MEMORANDUM

DATE: June 22, 2021

SUBJECT: SF-21-020 – Falcon Meadows at Bent Grass Filing No 1
First Submittal

Engineering Division

## FALCON MEADOWS AT BENT GRASS FILING NO. 1

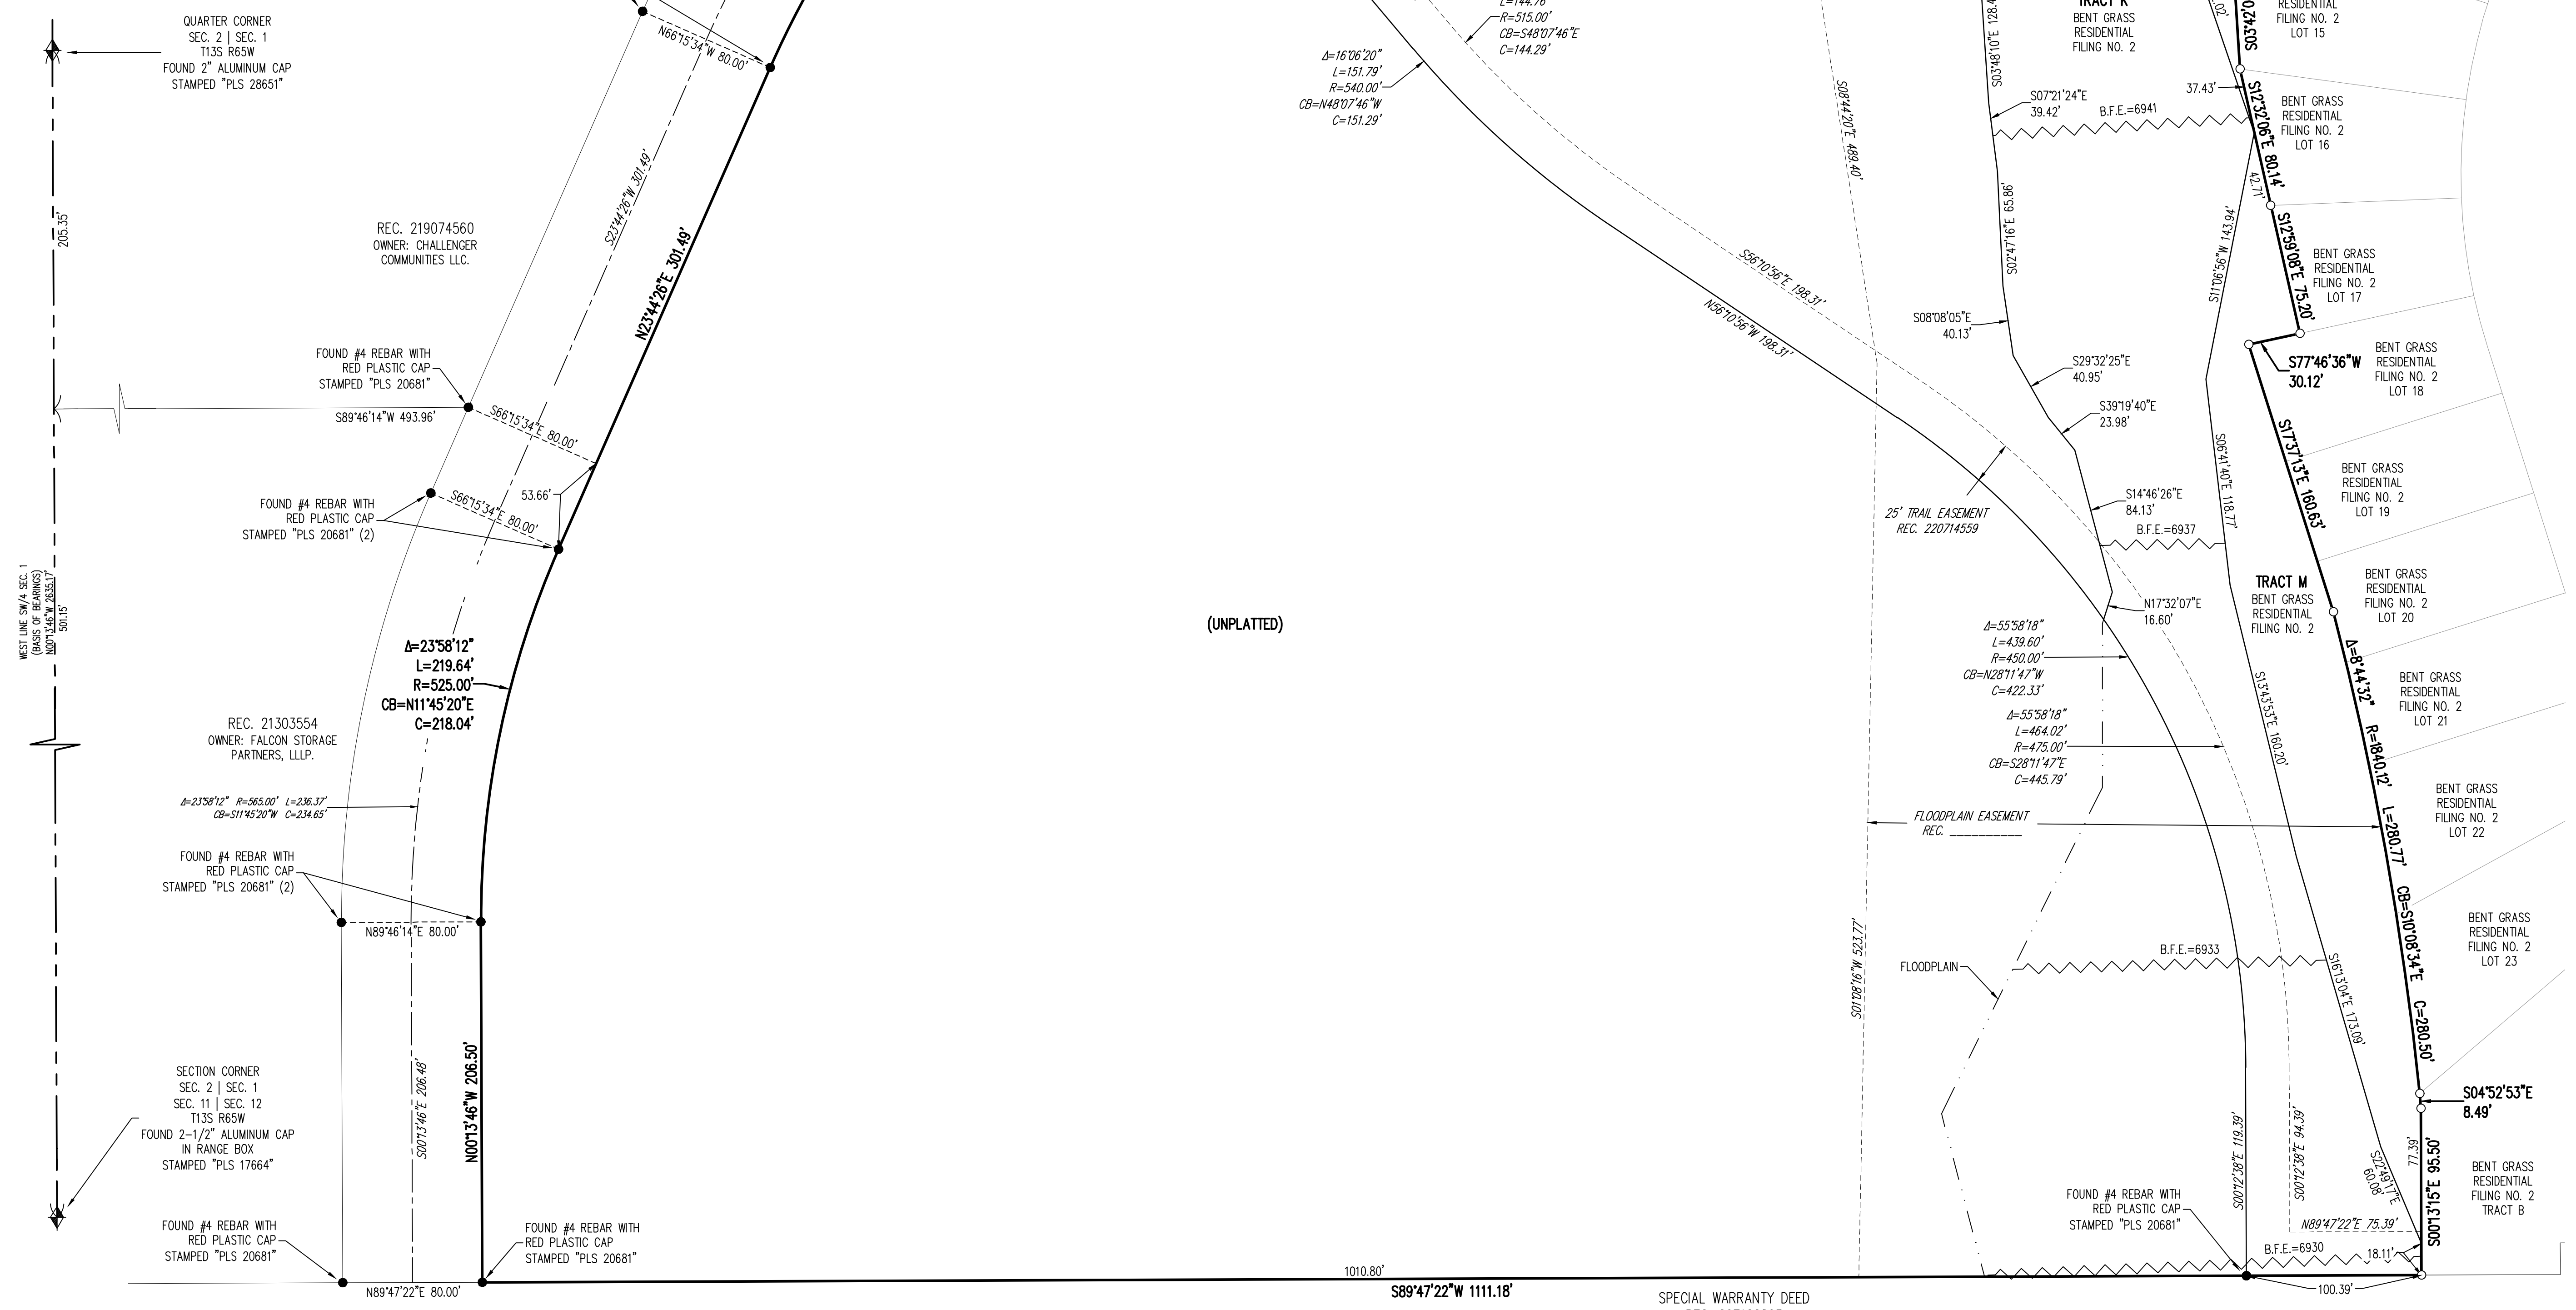
1. Revise the final plat to include the entire area southeast of Bent Grass Meadows Drive as indicated in the LOI. The channel needs to be in a tract with associated design and construction responsibilities (see FDR comments).

Response: Overall area has been updated (Total area – 21.3 acres).
2. Add the following plat notes:
 - There shall be no direct lot access to Bent Grass Meadows Drive. (add to Note #4)

- This property is subject to a Private Detention Basin/Stormwater Quality BMP Maintenance Agreement and Easement as recorded at Reception No. _____ of the records of El Paso County. The Bent Grass Metropolitan District is responsible for maintenance of the subject drainage facilities

- Bent Grass Metropolitan District shall be responsible for maintenance of the drainage channel in Tracts E and F until the necessary channel stabilization improvements have been constructed and accepted for maintenance by El Paso County.

Response: Notes have been added.
3. Show any ROW/easements needed for mail kiosks.
Response: Easements added for mailbox kiosks. Labeled as M.K.E.
4. See final plat redlines.

Response: Responses to redlines have been included.
